Re: 2501701-24035
497 Creekside Oaks South

Job	Truss	Truss Type	Qty	Ply	497 Creekside Oaks South	173936626
2501701-24035	A3_RP	ROOF TRUSS	4	1	Job Reference (optional)

REPAIR: SEE NOTE 1-3

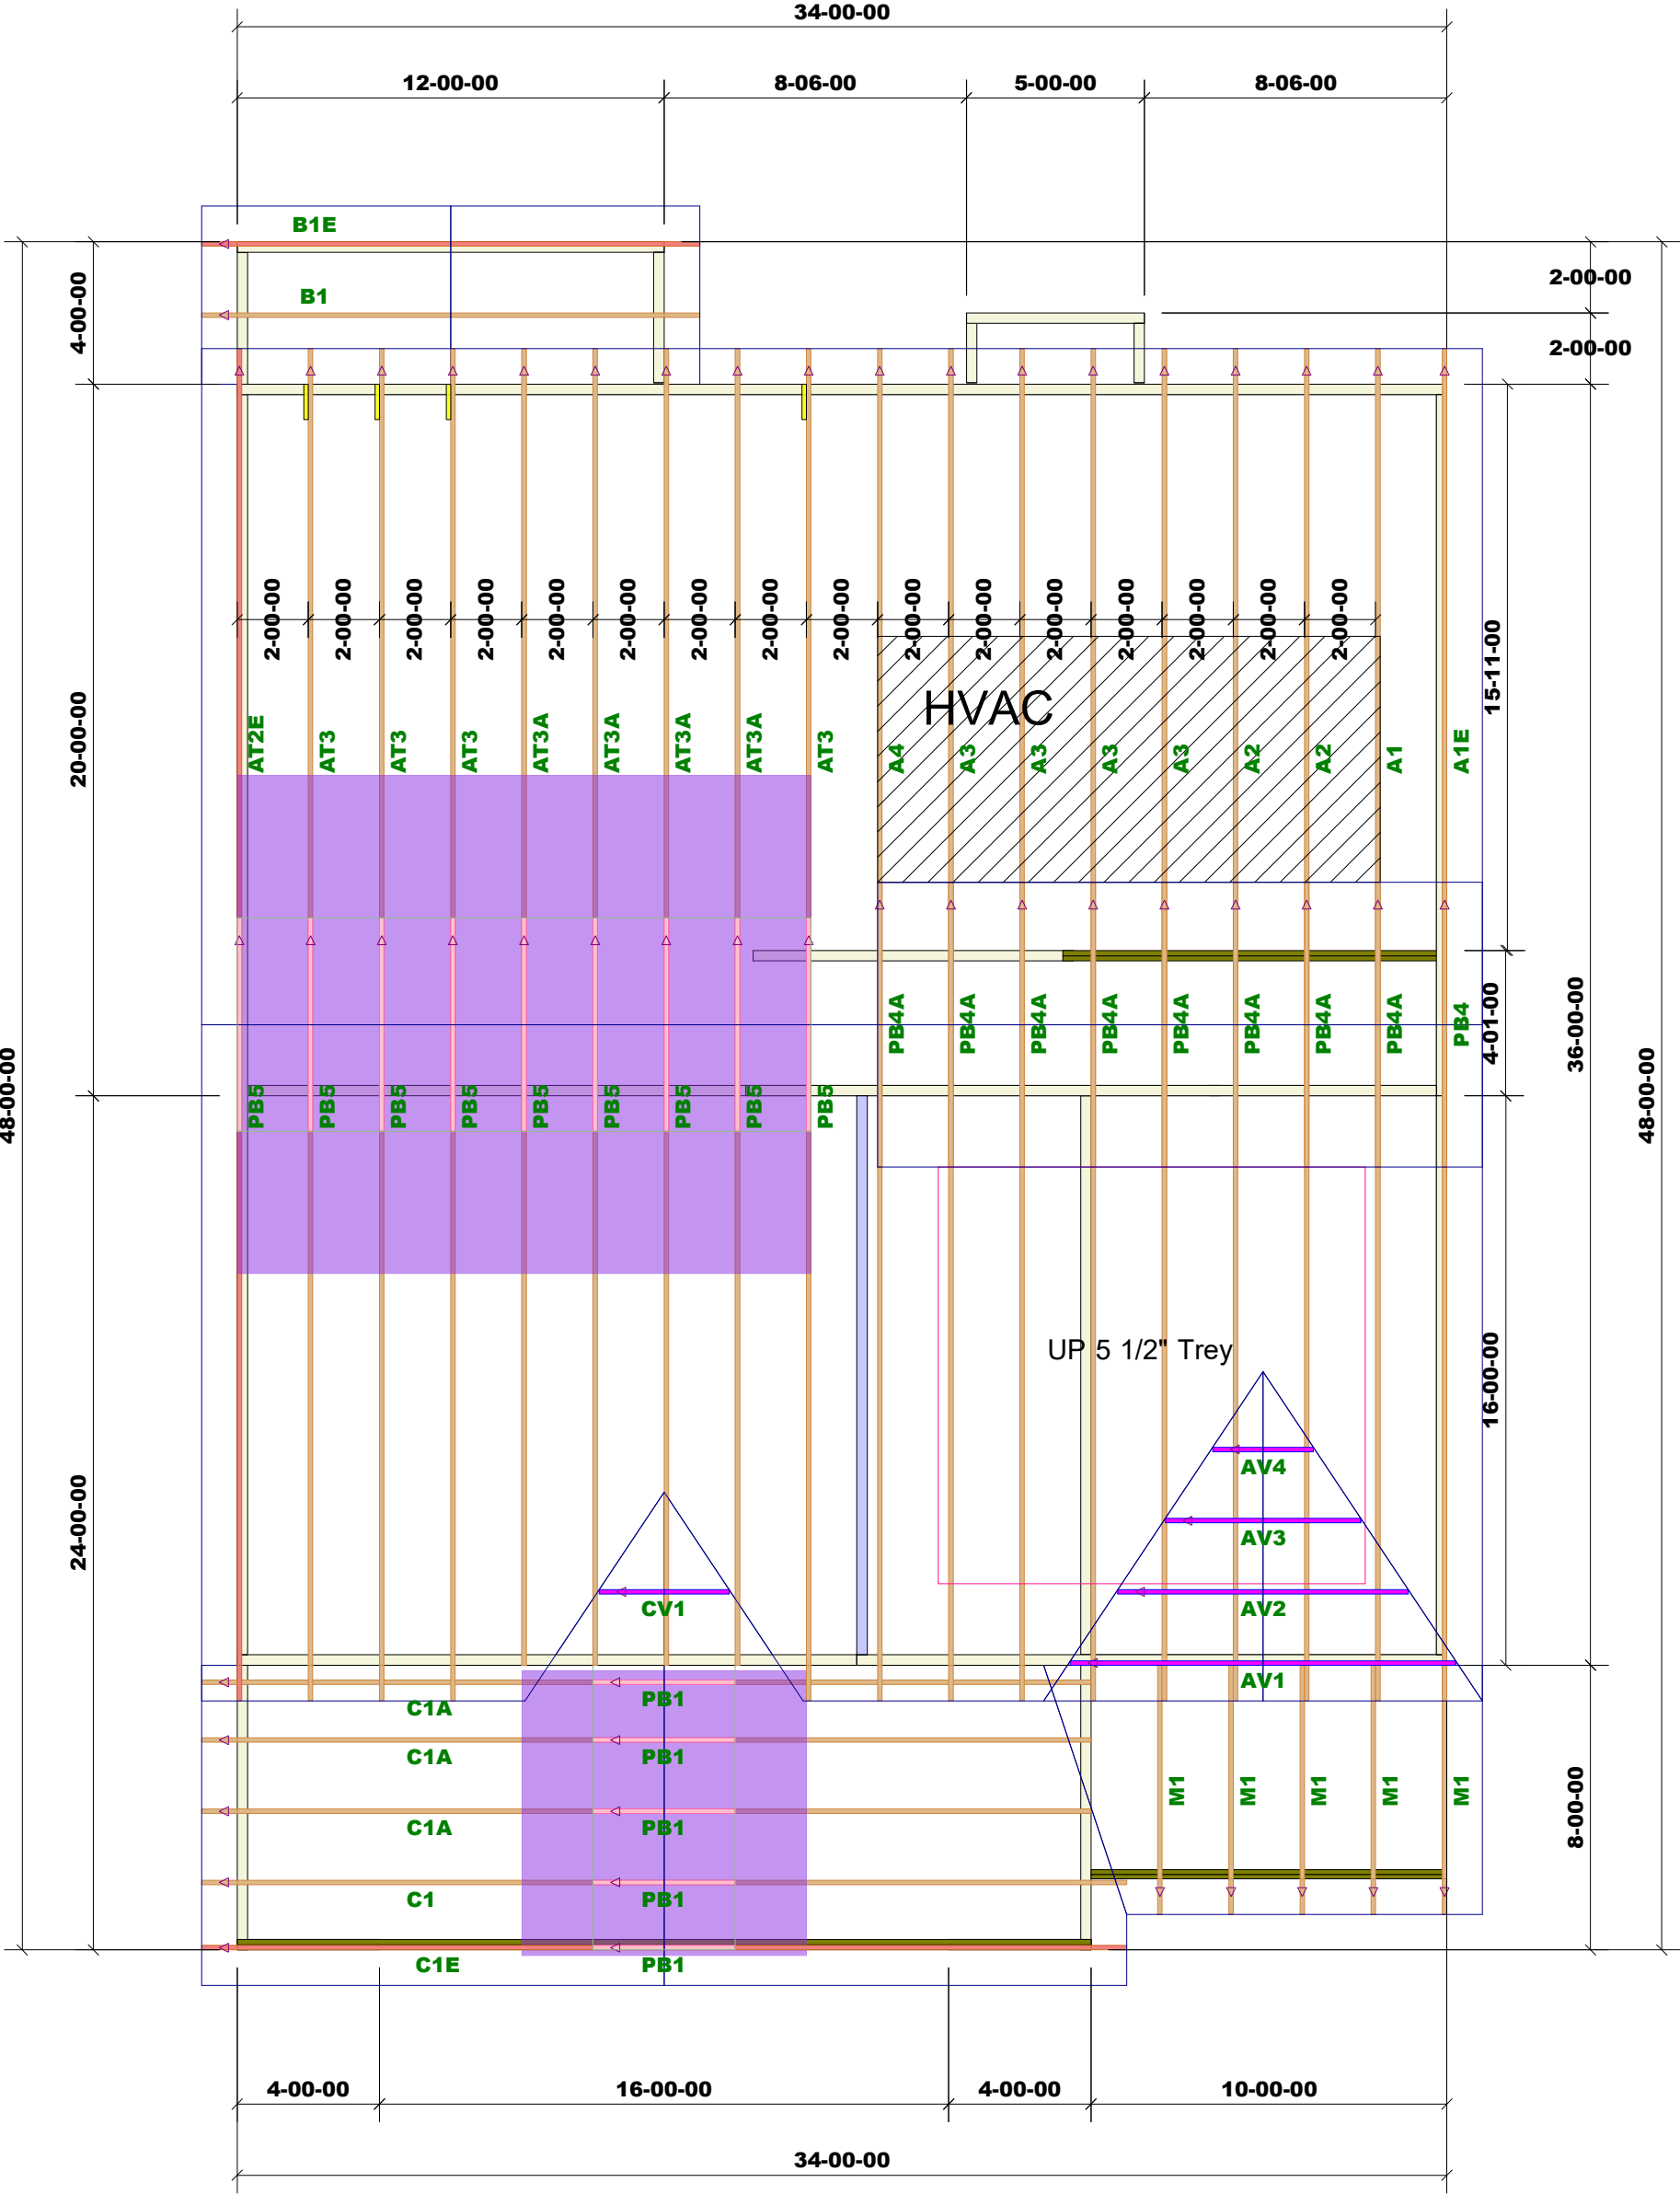
- 1) Repair Condition: web has 1-0-0 long break centered at 4-0-0 below joint 8.
- 2) Repair Condition: Missing or damaged plate(s) on one side(s) of truss at joint(s) 9.

APPLY 2 X 6 X 4' SP NO.2 SCAB(S) TO EACH FACE OF TRUSS CENTERED ON DAMAGE. ATTACH WITH (0.131" X 3") NAILS PER THE FOLLOWING NAIL SCHEDULE: 2 x 3'S - 1 ROW, 2 x 4'S - 2 ROWS, 2 x 6'S AND LARGER - 3 ROWS: SPACED @ 4" O.C. STAGGER NAIL SPACING FROM FRONT FACE AND BACK FACE FOR A NET 2" O.C SPACING IN THE TRUSS. USE 2" MEMBER END DISTANCE.

- 3) Attach 21"H X 32"W X 1/2" Plywood or OSB (15/32" APA Rated Sheathing 32/16 Exposure 1) gusset to both sides of truss at joint 9 with 8d (0.131"x2.5") nails from each face, driven through both sheets of plywood. Connected together as follows: 2x4 - 2 rows 0-4-0 o.c. Minimum 0-3-0 end distance.
